11 December 2019

RE: Notice of Exhibition - New Catherine Field Primary School (SSD 9477)

**PROPERTY: C O'Keefe Drive ORAN PARK
LOT: 1001 DP: 1234527**

**CATHERINE FIELD PS**  
NEW HIGH QUALITY CLASSROOMS  
DRAWING NAME  
**SEDIMENT AND SOIL EROSION CONTROL PLAN**

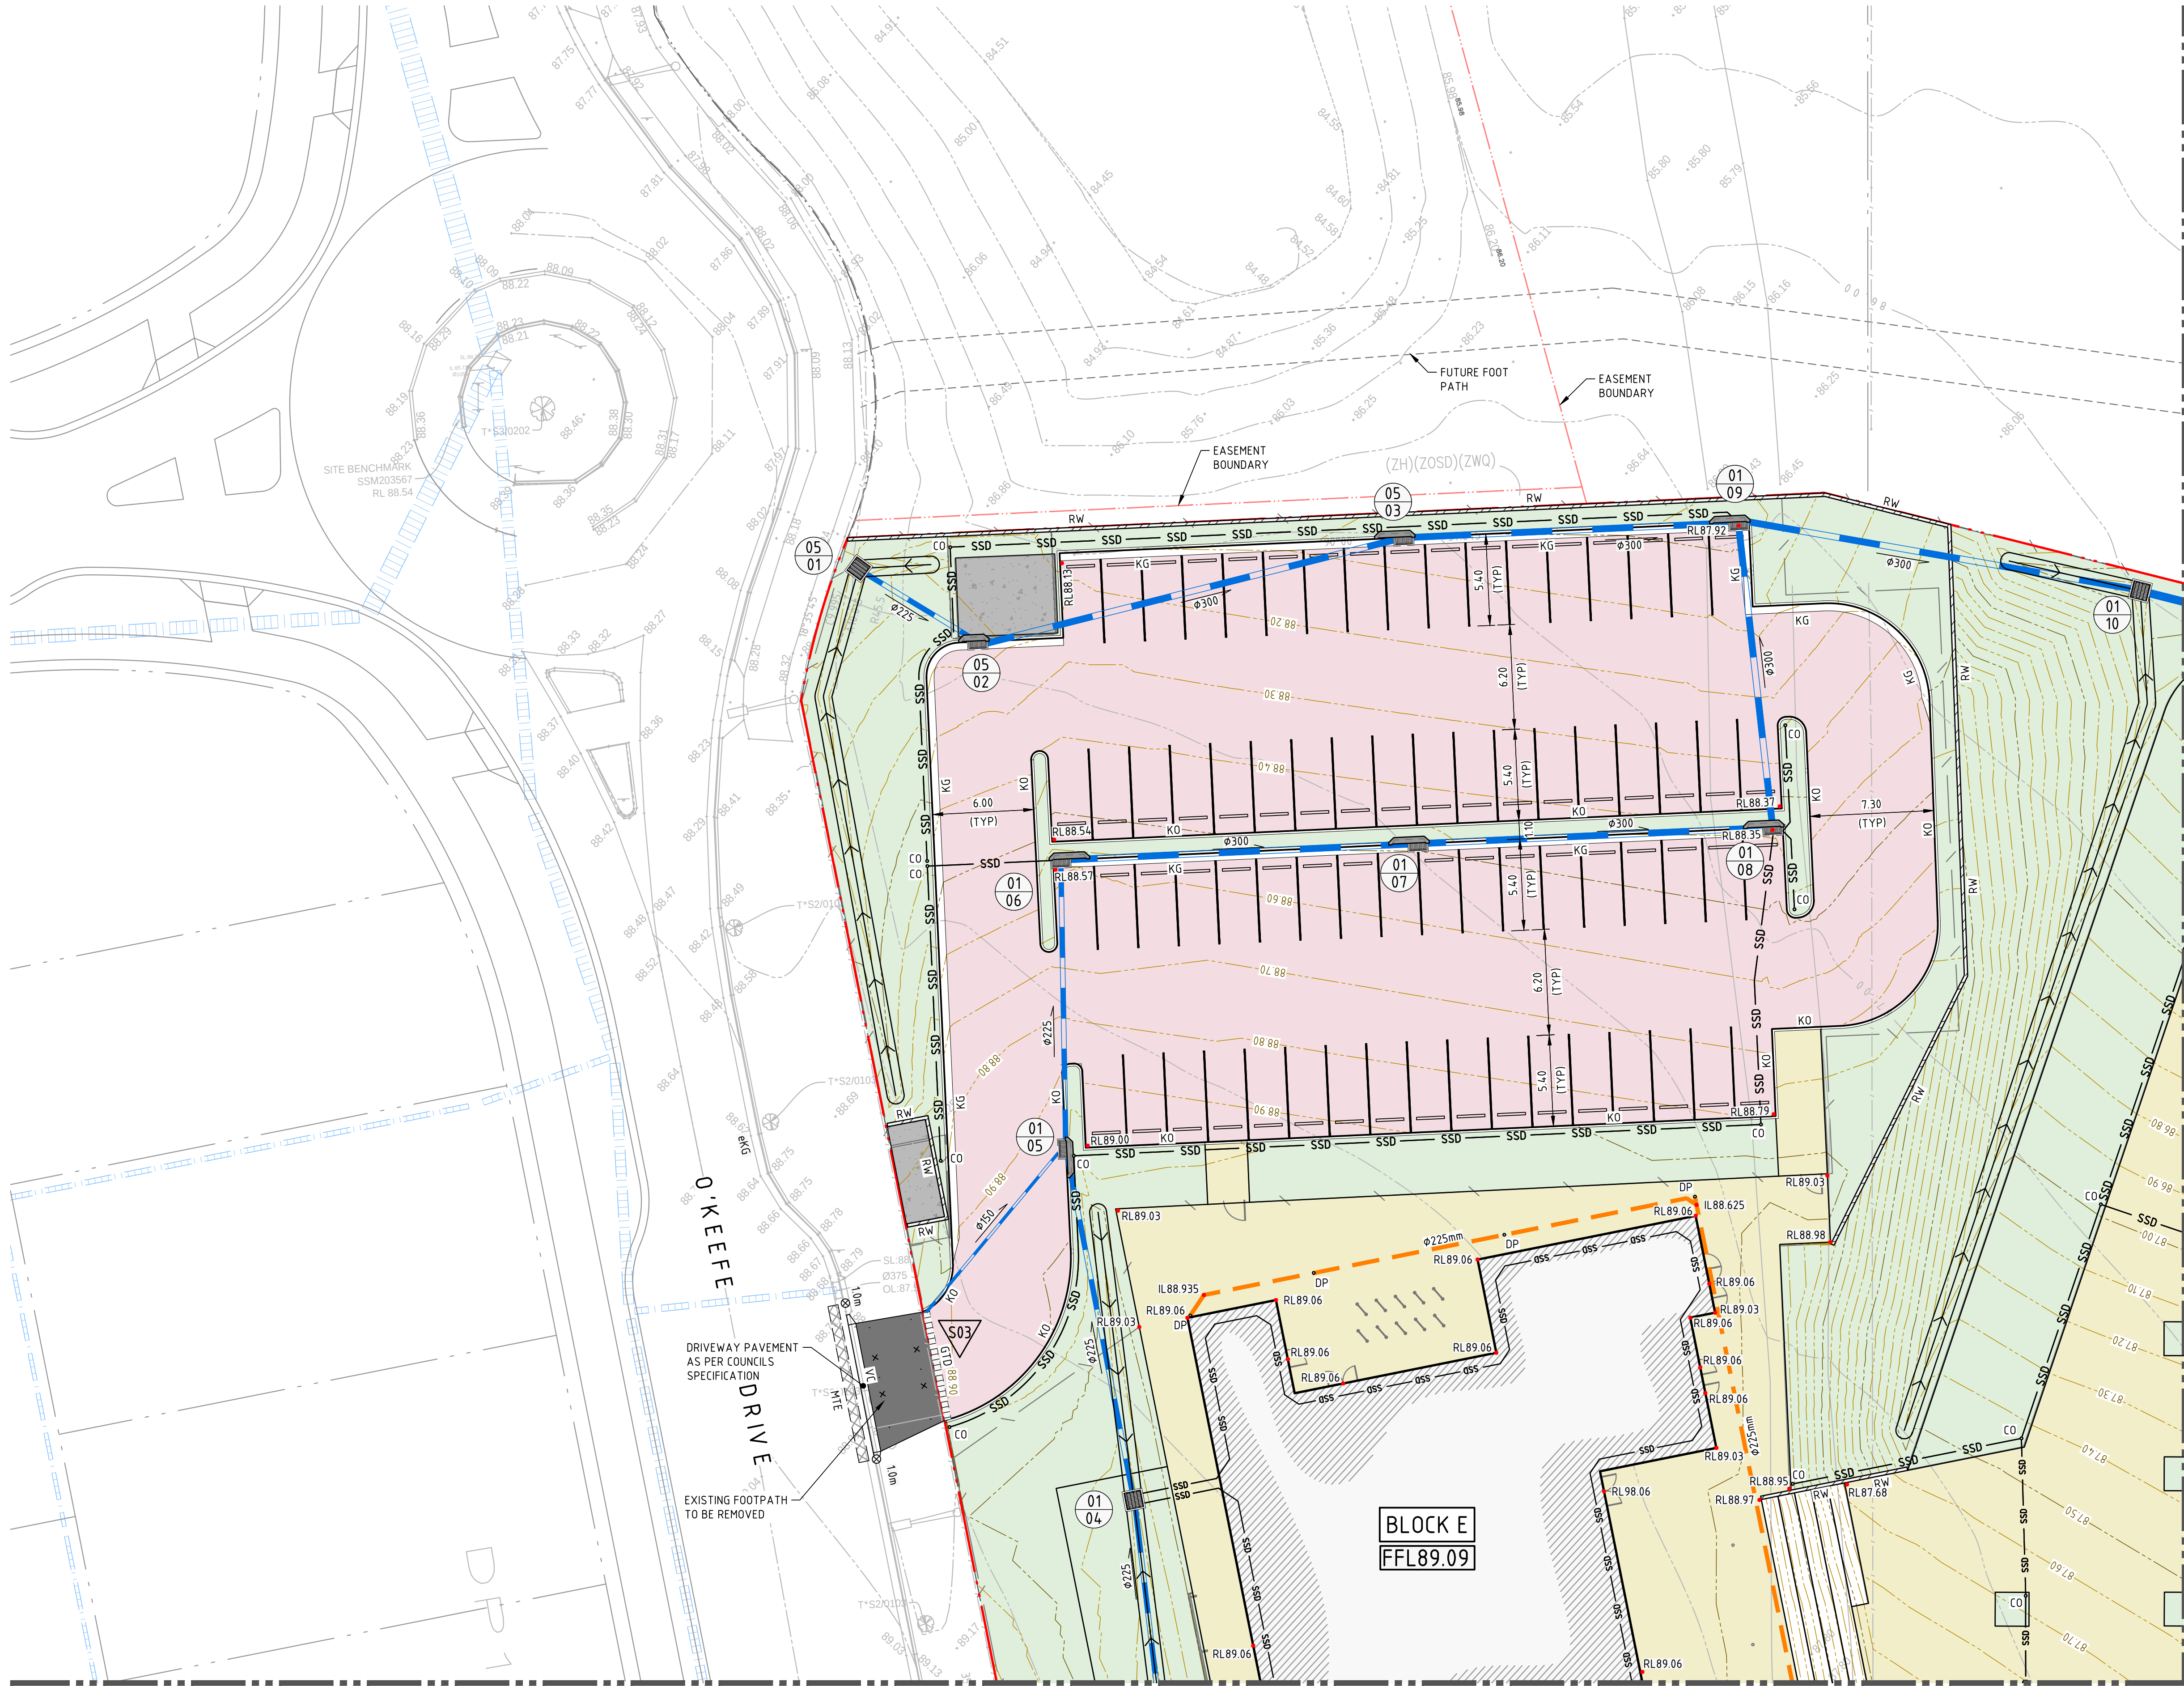
8. In the EIS, Table 8.0 (page 62) point 4.1.2 claims a cut fill plan is provided in Appendix G – it is not.
9. In the EIS Section 6.8 (page 74) states that Northrop has prepared a Concept Stormwater Design Report. Appendix G is just sediment and Erosion control plans. The statement saying "concluded that the site is not situated on flood prone" is not justifiable based on the documents supplied.

7. A cut/fill plan for the proposed site is required.
8. Further justification is required that demonstrates that the site is not subject to flooding. And confirm that all proposed floor levels are at or above the FPL.

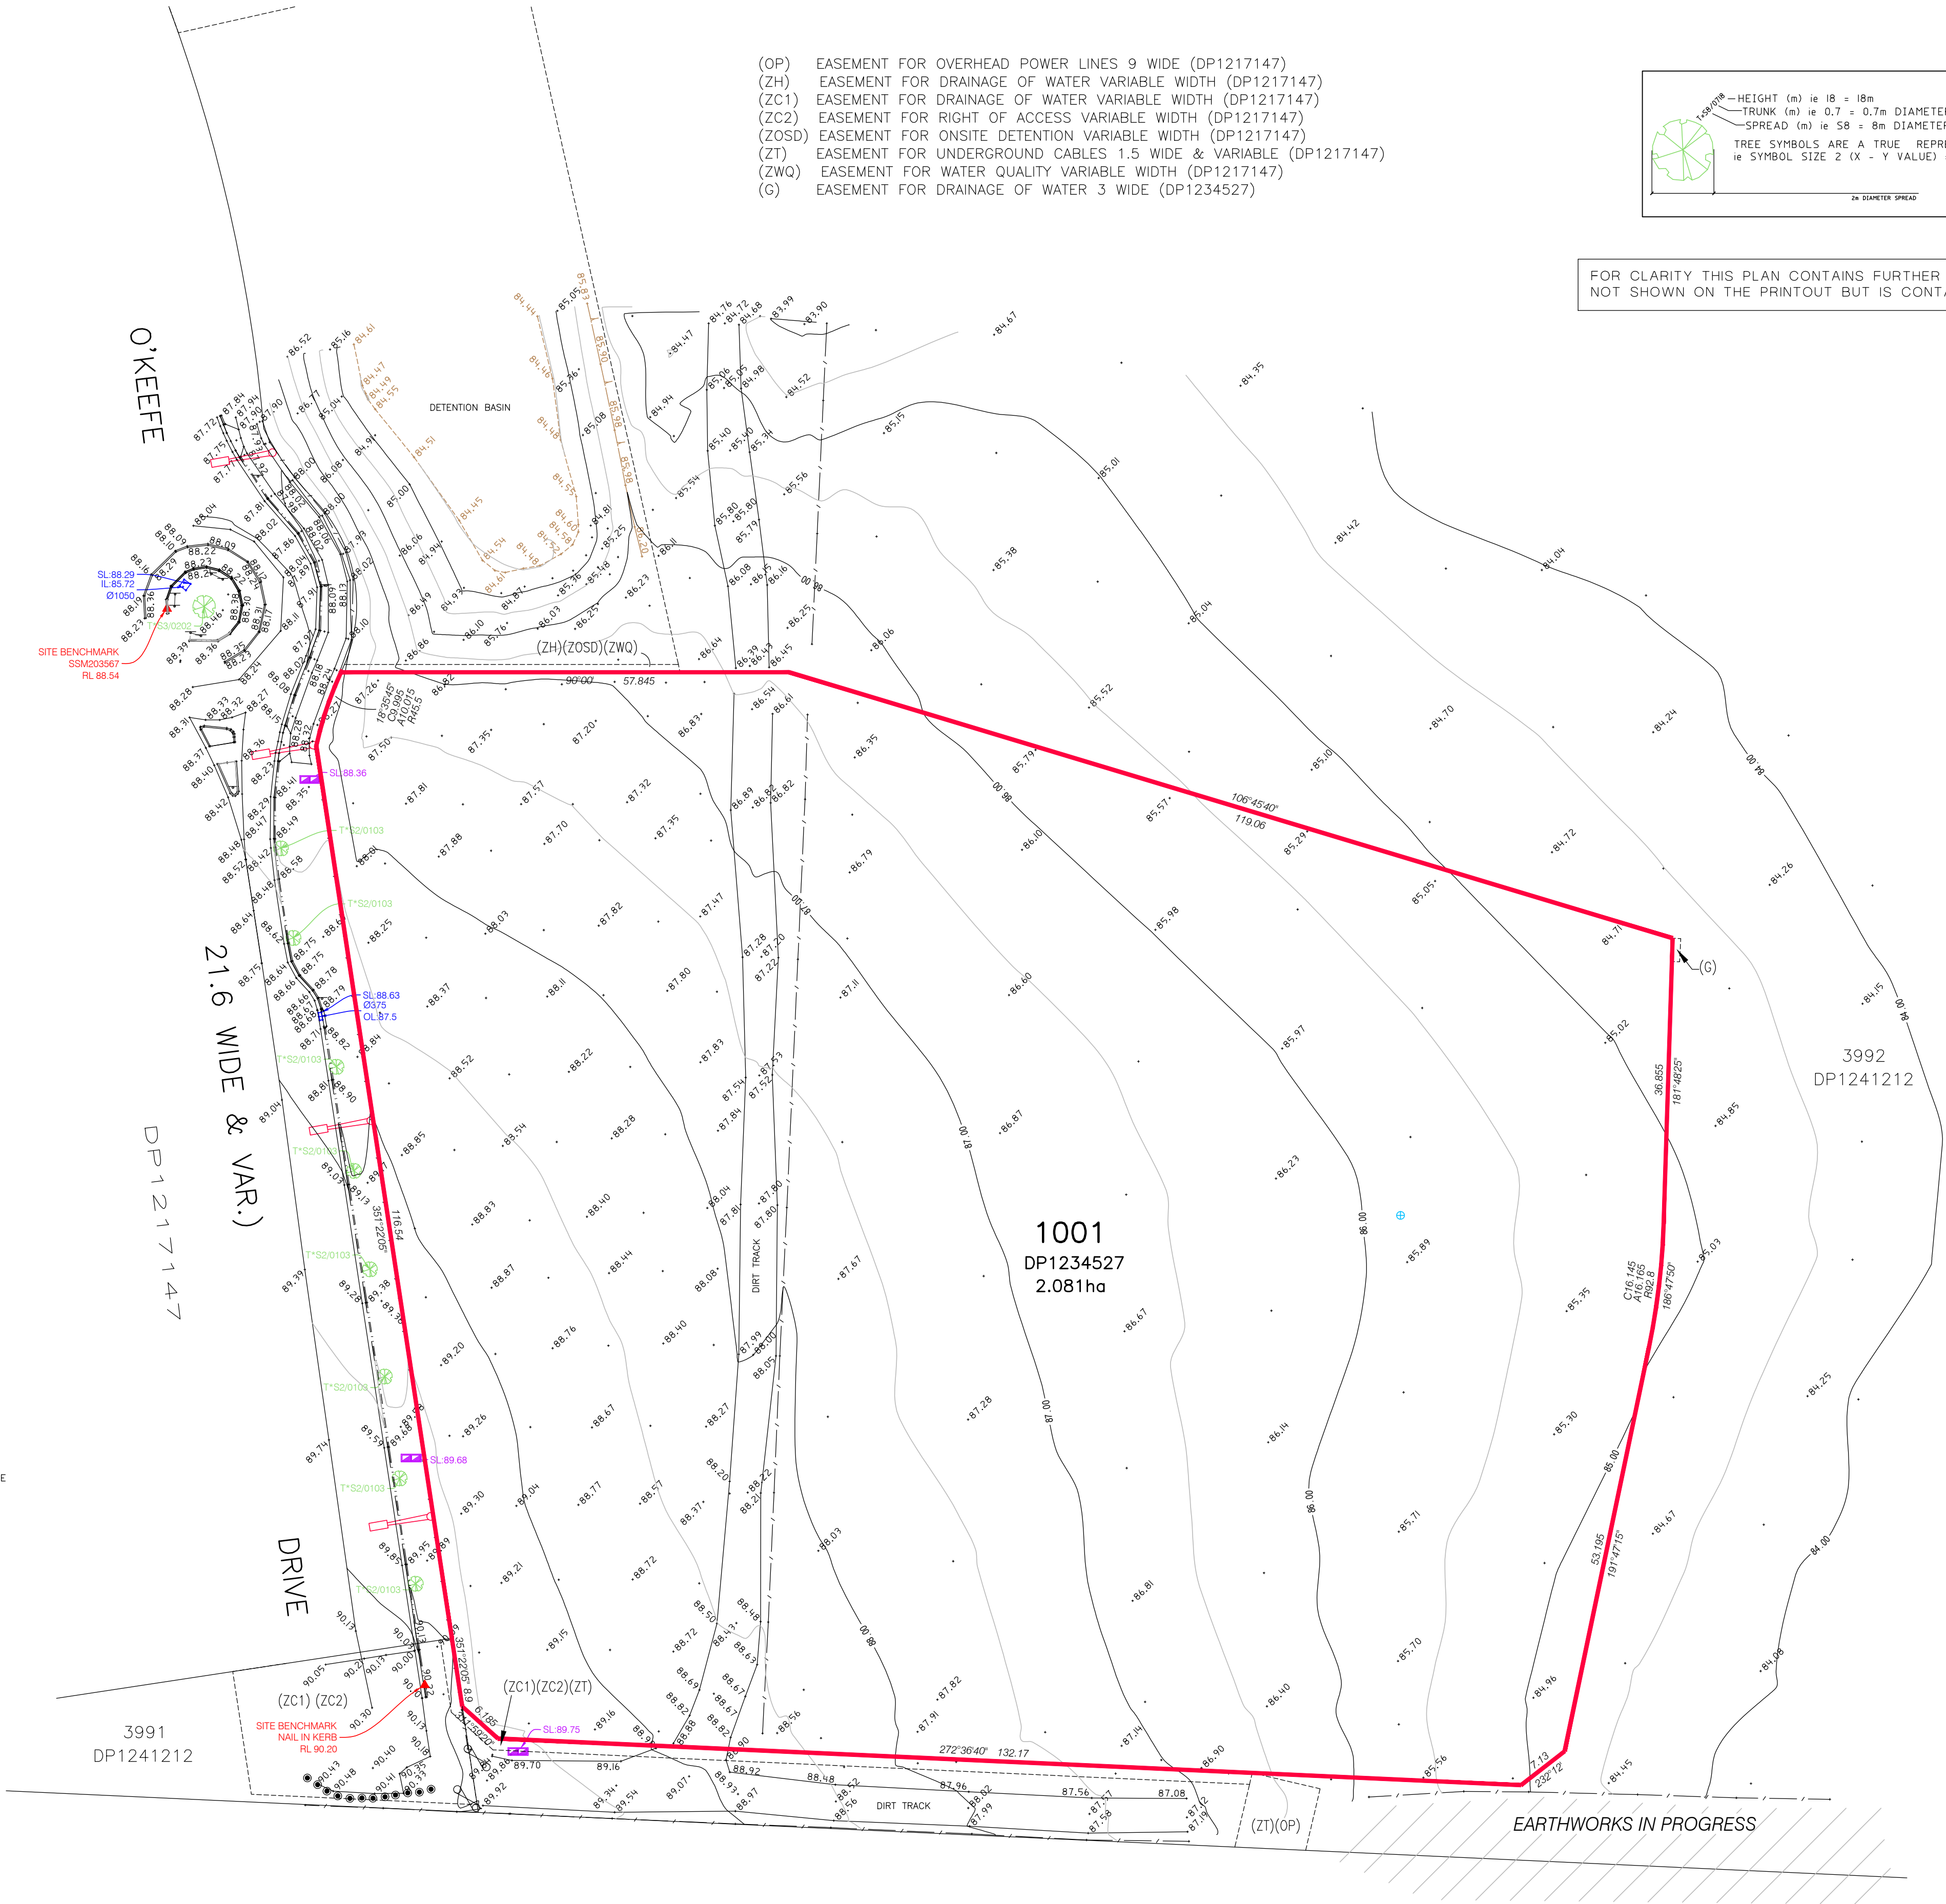
Confirmation shall be provided that the easement for overhead powerlines 9 wide through the site has been extinguished. If not, a referral to Endeavour Energy is required by State Environmental Planning Policy (Infrastructure) 2007.

The 'existing levels' shown on the engineering plans shall be amended to reflect the approved levels of previously approved applications (depending on proposed sequencing) as well as the proposed early works DA.
